From:
Sent: 11 February 2026 12:46
To: DC Admin
Subject: 2025/60/93572/E - objection to application

I formally object to this outline planning application.

Layout For Illustration Purpose Only.

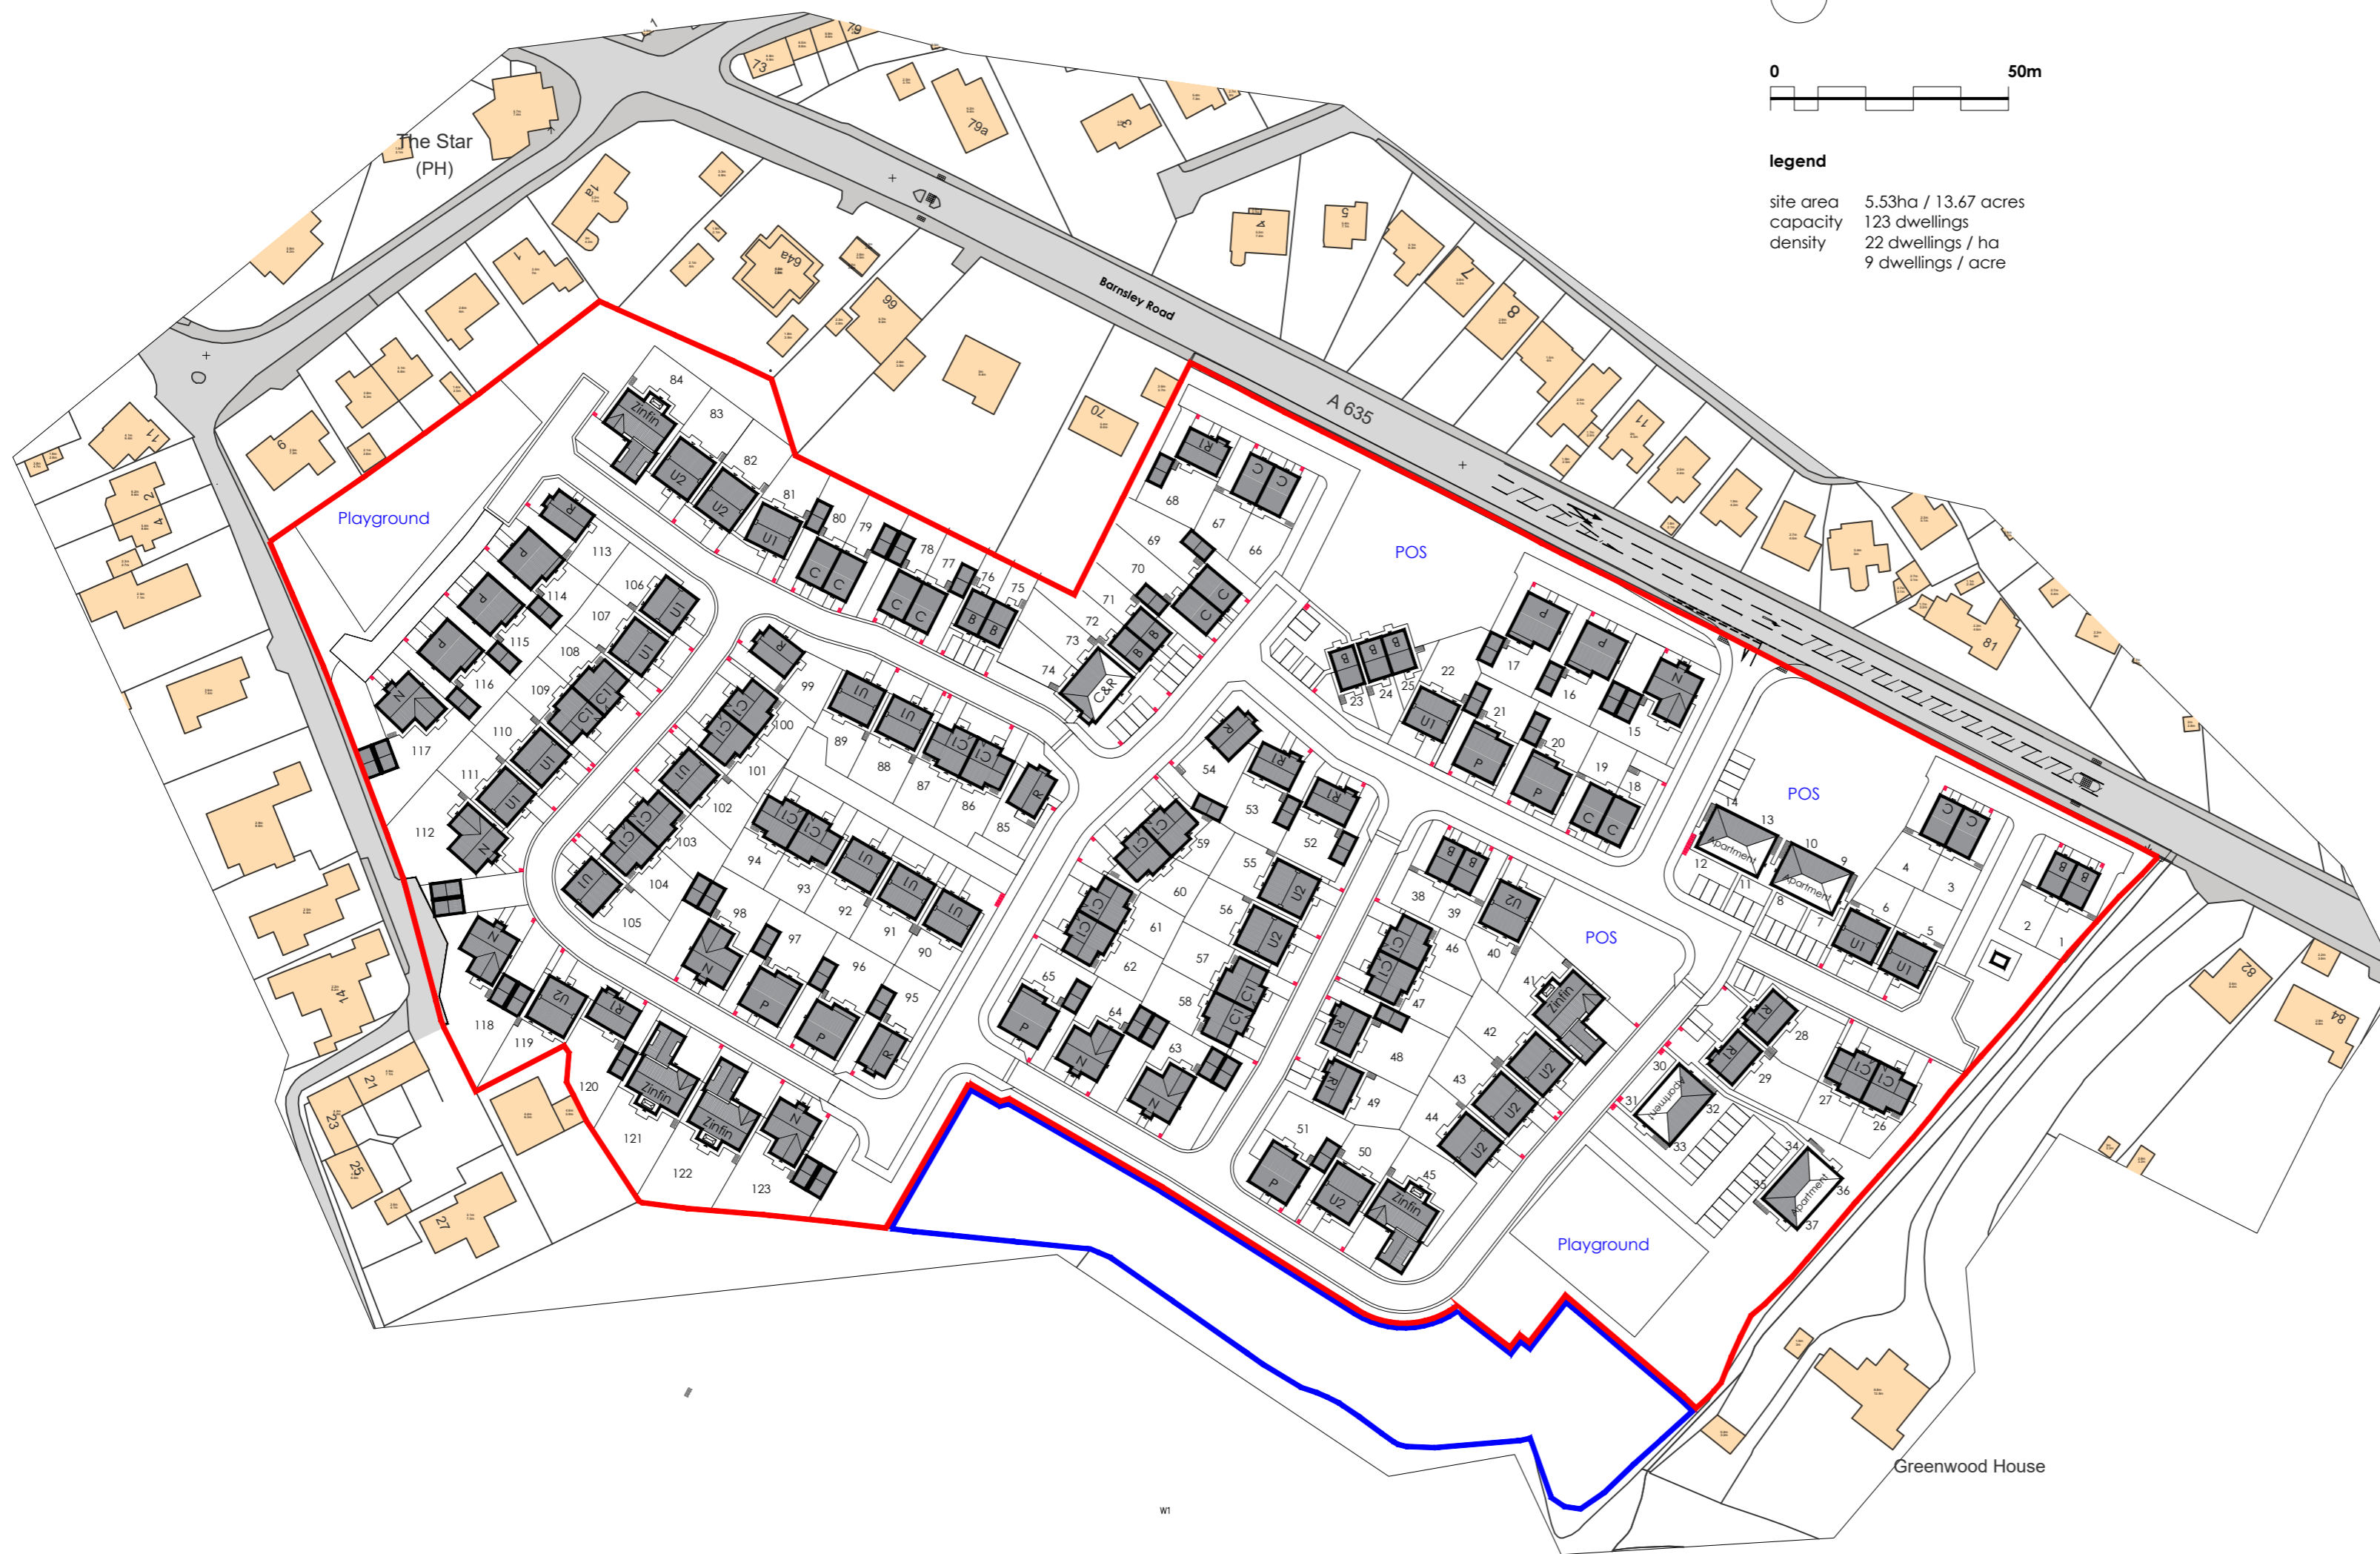
The indicative layout submitted does not adequately respond to the site's constraints or policy context.

Good design is required under both national policy (NPPF Section 12) and the Kirklees Local Plan, which emphasise that development should be informed by site characteristics, landscape setting, ecological assets, and infrastructure capacity. The proposed layout appears to be a standard housing arrangement rather than one genuinely shaped by the site's environmental and policy constraints.

In particular, the layout fails to:

- Demonstrate appropriate respect for the adjacent ancient woodland and its required buffer.
- Reflect the sensitivity of the Green Belt setting and the importance of openness.
- Respond to local topography and long-distance views.
- Address drainage constraints in a meaningful or evidenced way.
- Show how ecological corridors and foraging habitats would be retained and enhanced.

Instead, the layout appears to attempt to maximise dwelling numbers rather than respond sensitively to site context. This further reinforces the conclusion that the site is unsuitable for development and that its value lies in remaining as open Green Belt countryside.
